CITY OF ALBUQUERQUE

**RE: Guardian Storage- Juan Tabo
4909 Juan Tabo NE
Conceptual Grading and Drainage Plan Stamp Date: none
Hydrology File: F21D081**

Based on the submittal received on 11/12/19, the Conceptual Grading and Drainage Plan cannot be approved until the following are corrected:

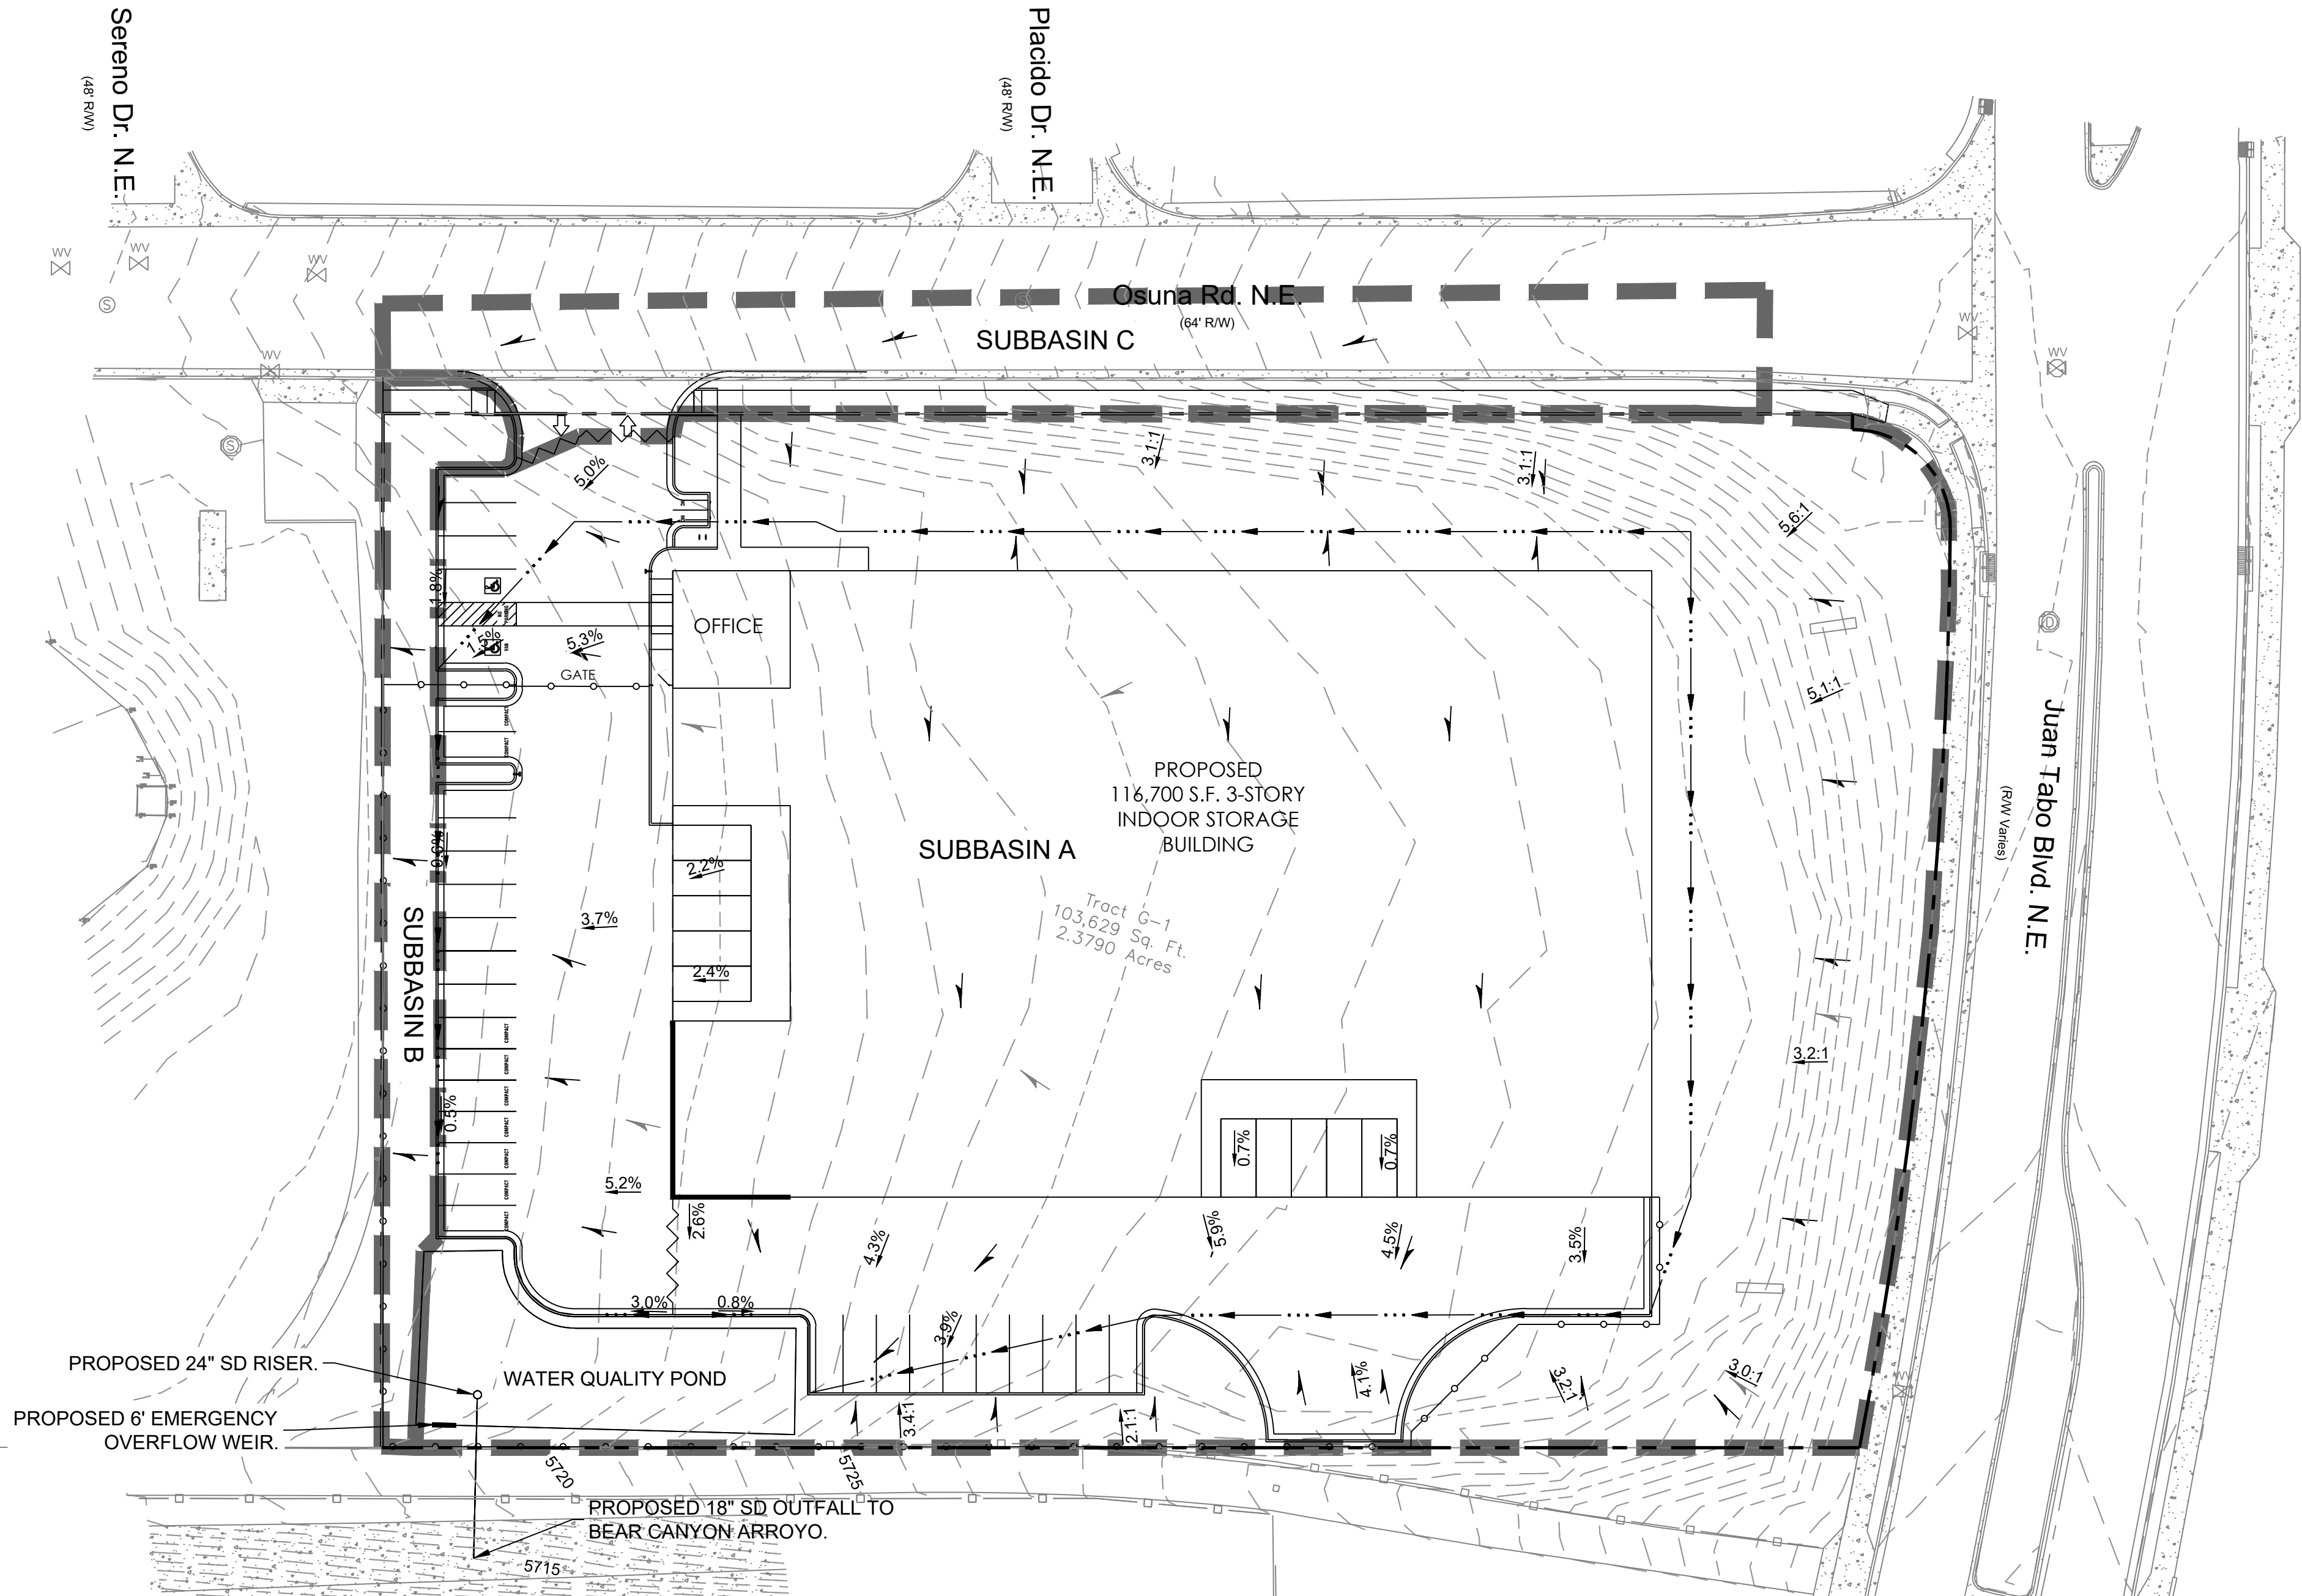
4. Provide slope easements (3:1) from the edge of ROW/PL down to the proposed grade along Juan Tabo, Osuna, and the arroyo.
5. Provide slope protection anywhere slopes exceed 3:1.

7. Provide a waterblock, 0.87' high at the drive entrance. Alternatively, provide flow depth (and EGL) calculations along Osuna to justify a lesser waterblock.

SHEET TITLE:
CONCEPTUAL
DRAINAGE PLAN

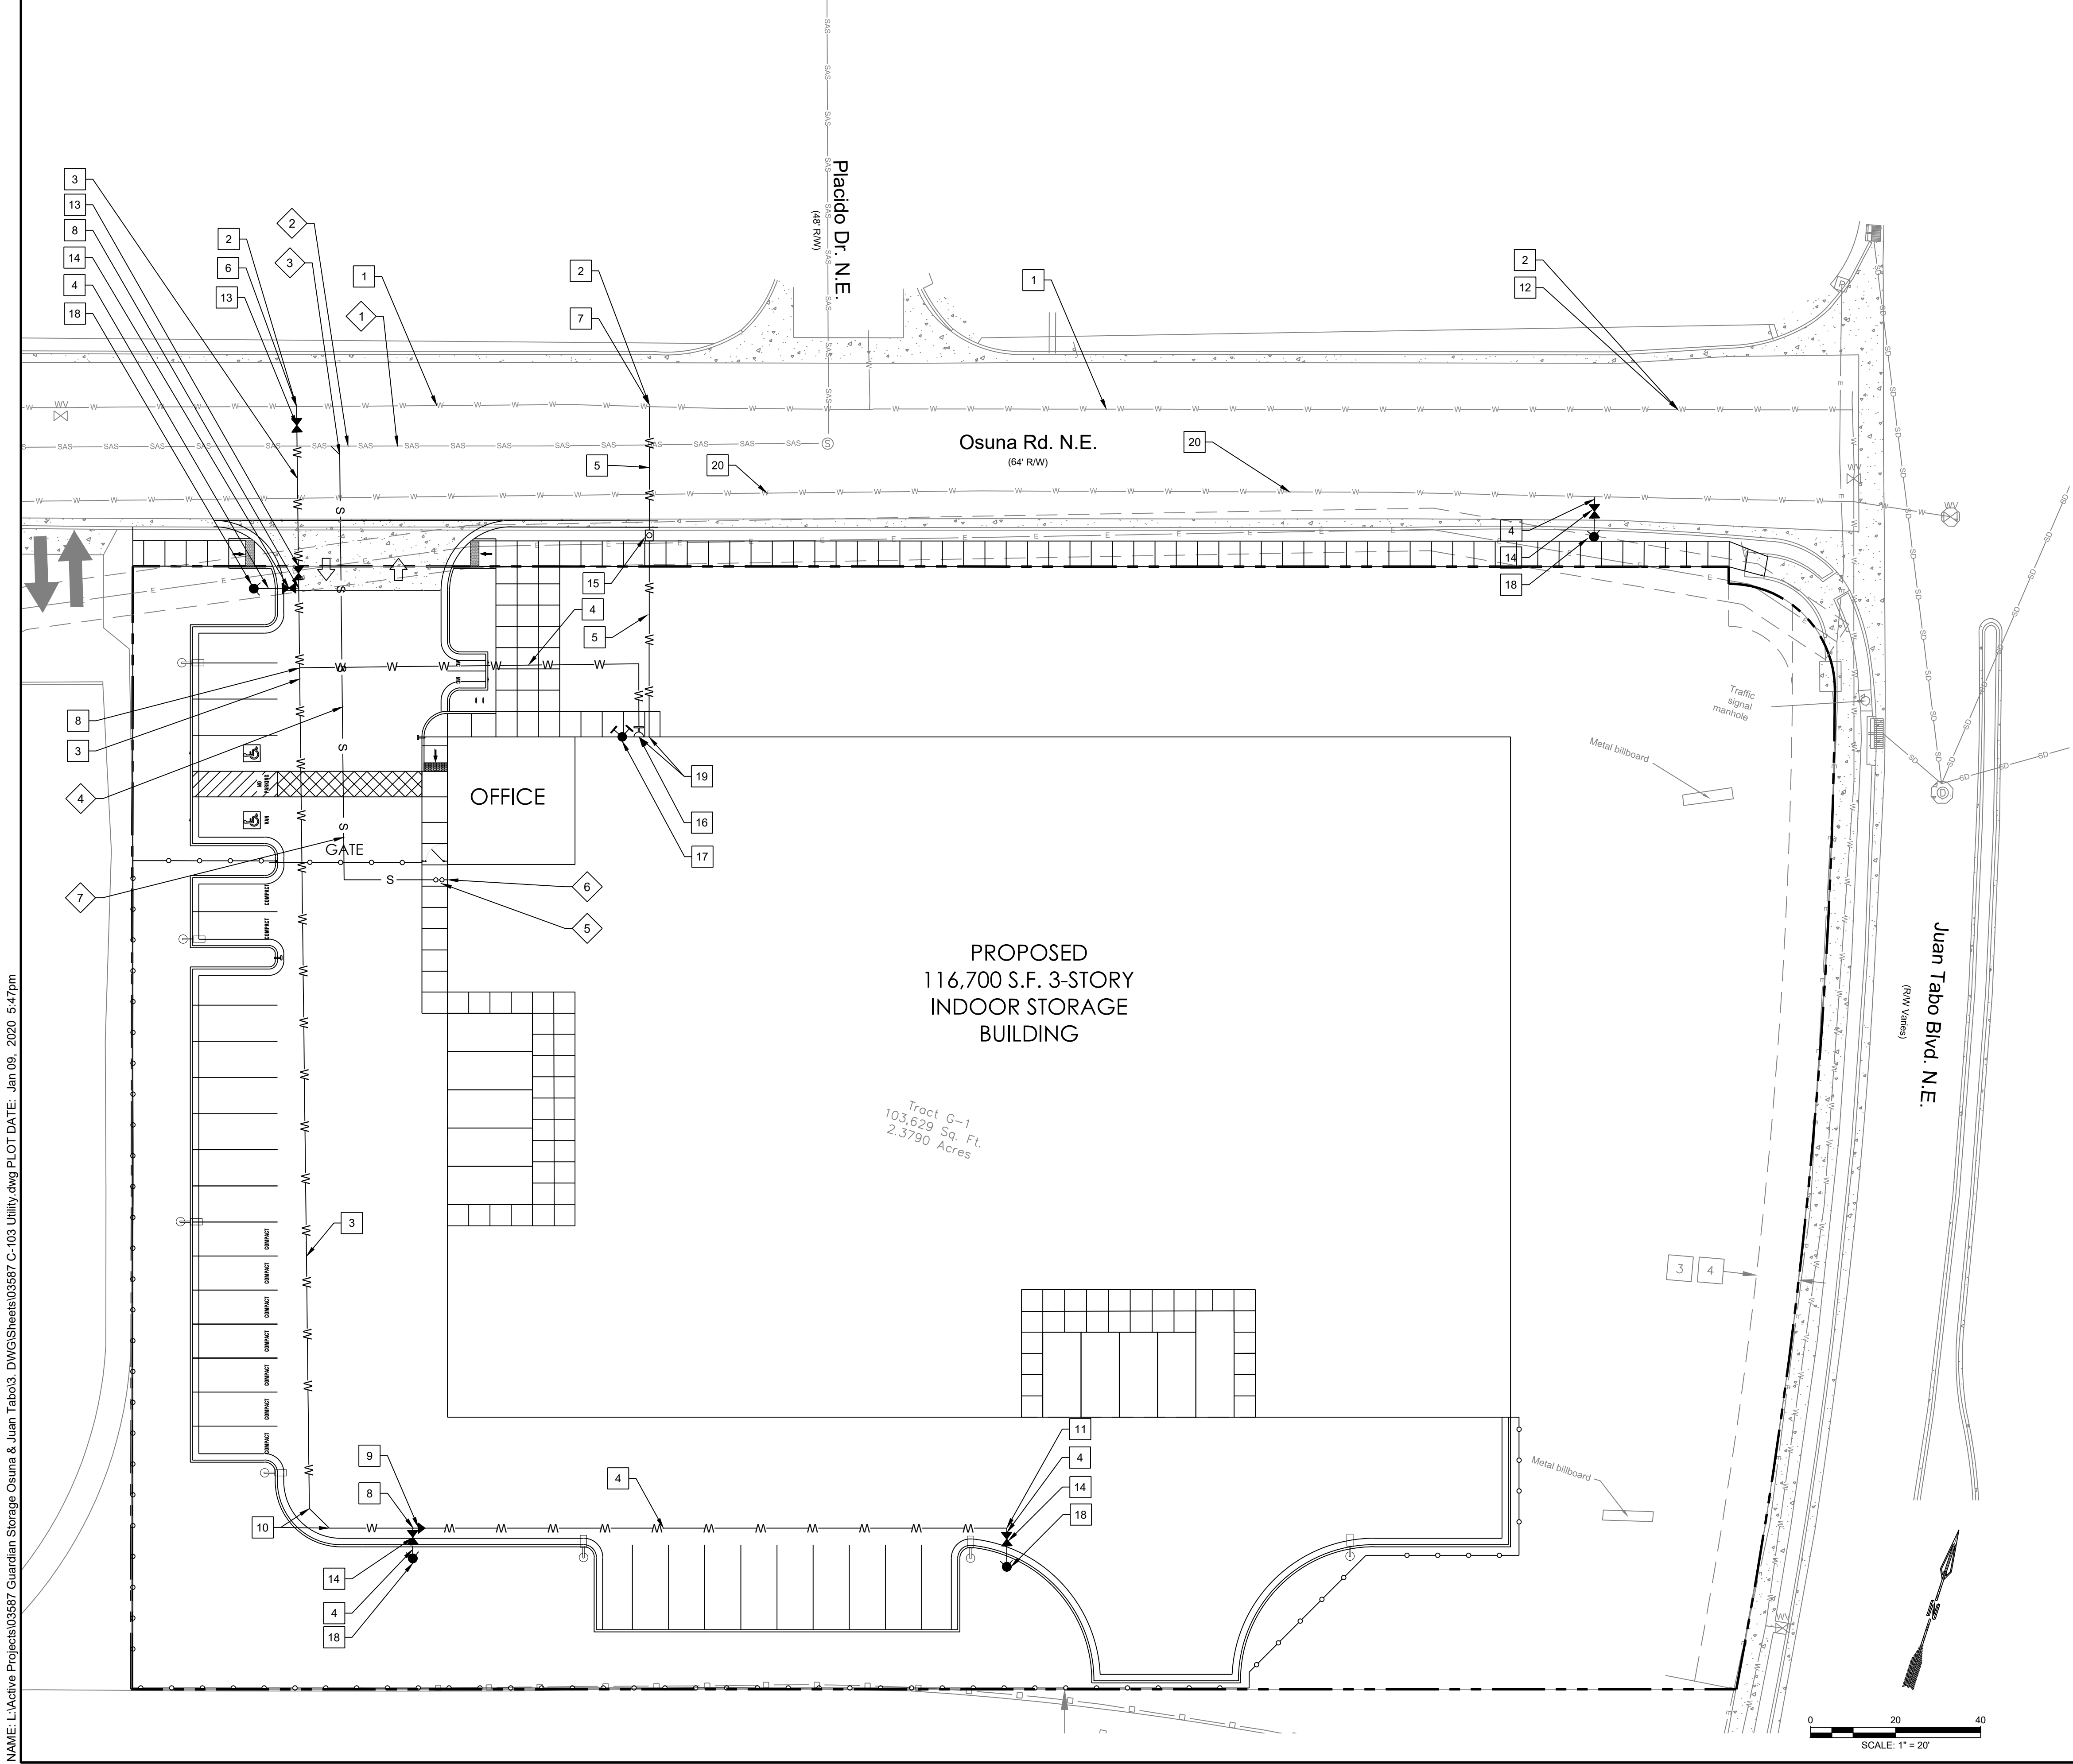
3. The discharge to Bear Canyon Arroyo shall be by City Work Order using an RCP pipe penetration into the standard concrete portion of the channel, per AMAFCA Standard Detail 103 or 104. This work needs to be included on the infrastructure list.

6. Provide an emergency spillway (or 2x capacity on the outfall), sized for the 100-yr peak inflow on the proposed pond. The spillway must be directed to the arroyo easement, not the property to the west.
